**Gatwick Northern Runway
TR020005**

**COMMENTARY ON OUTLINE CONSTRUCTION
TRAFFIC MANAGEMENT PLAN**

NATIONAL HIGHWAYS LIMITED
PROPOSED GATWICK AIRPORT NORTHERN RUNWAY PROJECT
MARK UP OF OUTLINE CONSTRUCTION TRAFFIC MANAGEMENT PLAN [APP-085]

Appendix A: Gatwick NRP Temporary Compounds and Construction Vehicle (HGV) Access Routes

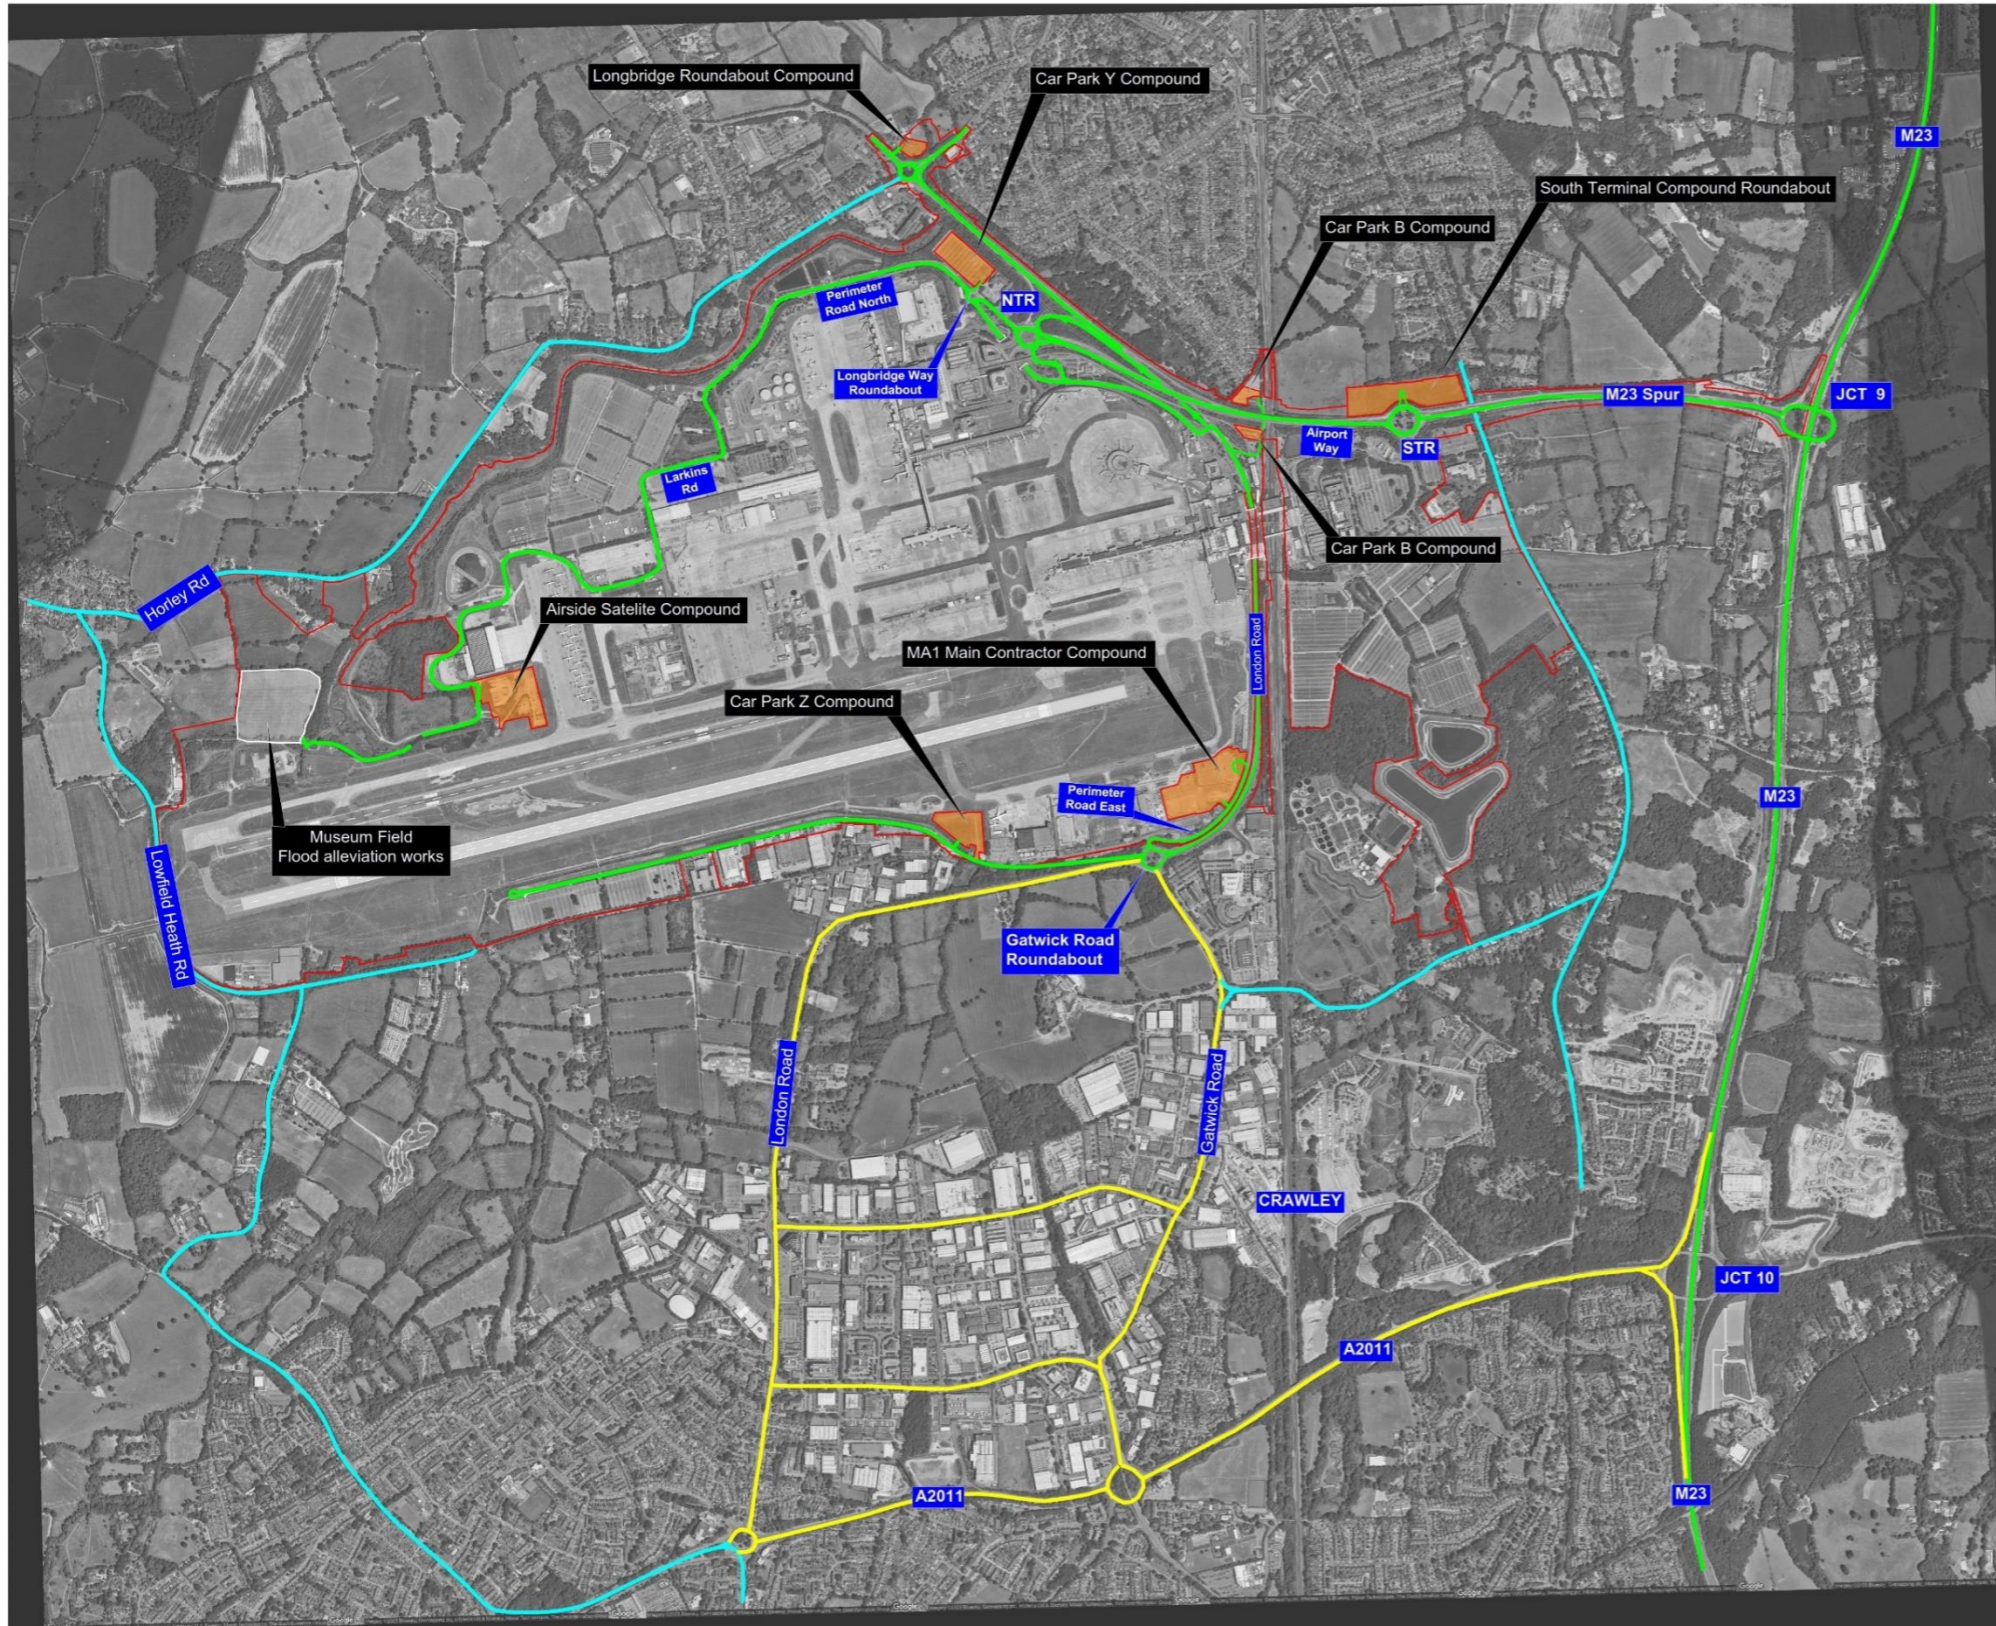
Commented [BDBP20]: In Appendix A the Applicant sets out three categories of routes (Primary, Contingency and Restricted Use). The Applicant should make commitments in respect of all three, not just two.
